Canal & River Trust

Your Ref 23/02098/OUT

Proposal: Outline application, with all matters reserved, for a multi-phased (severable), comprehensive residential-led mixed use development comprising: Up to 215,000 square metres gross external area of residential floorspace (or c.1,800 homes which depending on the housing mix could result in a higher or lower number of housing units) within Use Class C3/C4 and large houses of multiple occupation (Sui Generis); Supporting social infrastructure including secondary school/primary school(s) (Use Class F1); health, indoor sport and recreation, emergency and nursery facilities (Class E(d)-(f)). Supporting retail, leisure and community uses, including retail (Class E(a)), cafes and restaurants (Class E(b)), commercial and professional services (Class E(c)), a hotel (Use Class C1), local community uses (Class F2), and other local centre uses within a Sui Generis use including public houses, bars and drinking establishments (including with expanded food provision), hot food takeaways, venues for live music performance, theatre, and cinema. Up to 155,000 net additional square metres (gross external area) of flexible employment uses including re

Figure 2—1 Illustrative Masterplan

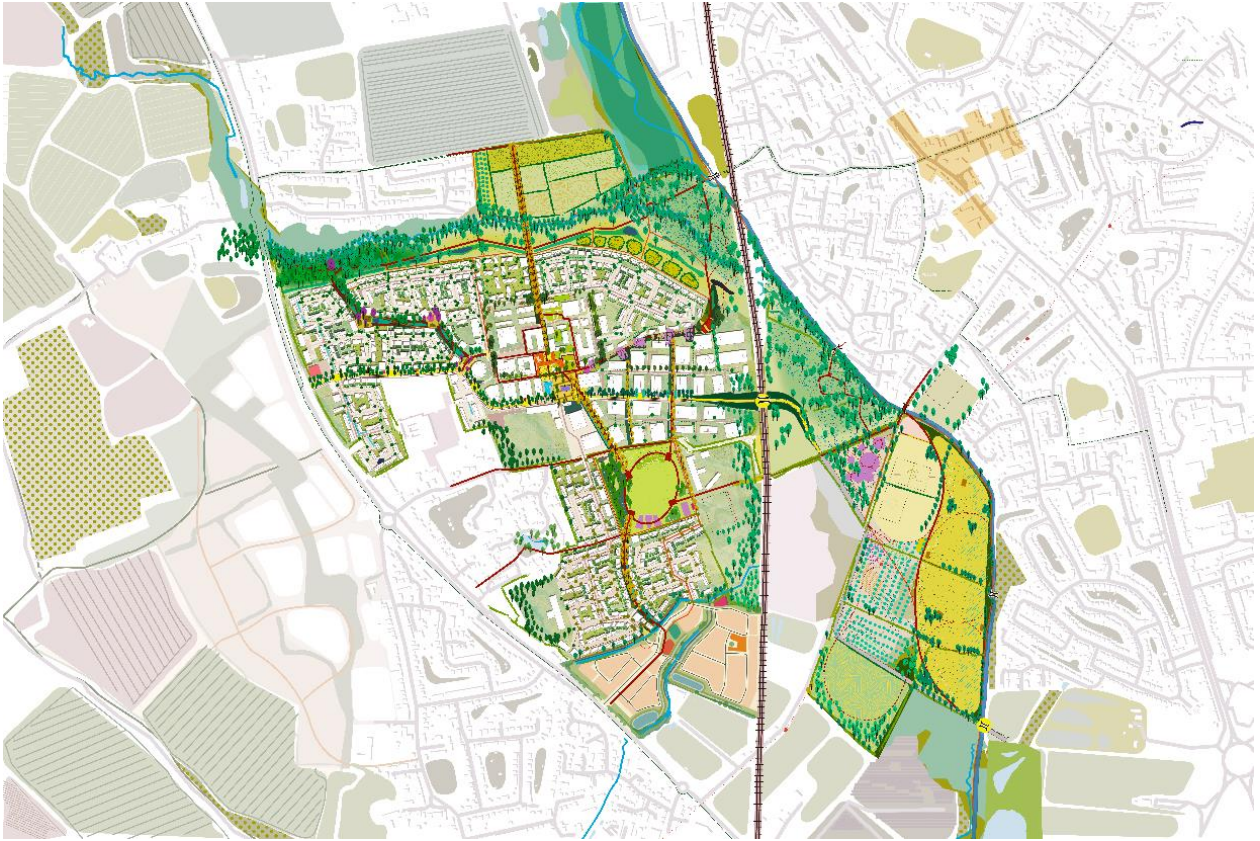
The masterplan shows pathways leading to the canal and various crossing points using existing bridges. Most of these bridges are not in the ownership of the Trust.

It should be noted that one of the links across the canal shown on the masterplan is not an existing bridge, but a lock gate crossing (Kidlington Green Lock). Lock gates are not considered a safe means of crossing the canal for members of the general public. They are only provided to give access to the offside for boaters needing to operate lock gates. There is no onward route and use of the lock landing (the area of land adjacent to the lock on the offside) is not encouraged other than for operational purposes. This crossing should be removed from future iterations of the plan.

A new bridge is shown over the canal, but this is not included within the site boundary. A new bridge cannot be erected without the agreement of the Canal & River Trust, it will need a commercial agreement and DEFRA consent. Any new bridge will be required to comply with detailed design guidance which can be found at [Code of Practice for Works Affecting the Canal and River Trust Part 2 - Detailed Information \(canalrivertrust.org.uk\)](https://www.canalrivertrust.org.uk/Code-of-Practice-for-Works-Affecting-the-Canal-and-River-Trust-Part-2-Detailed-Information). Further information on bridge design (although specifically relating to new HS2 crossings) can be found at [Creating successful waterside places | planning and design | Canal & River Trust \(canalrivertrust.org.uk\)](https://www.canalrivertrust.org.uk/Creating-successful-waterside-places-planning-and-design). These standards are to protect both navigational safety and the safety of towpath users.

The wastewater weir currently discharges into Kingsbridge brook. Which runs along the back of the towpath and potentially within the boundary of the development based on the illustrative masterplan. An easement that allows the Trust access to the brook to carry out future maintenance, thus enabling us to adequately maintain our navigation water levels would be of assistance.
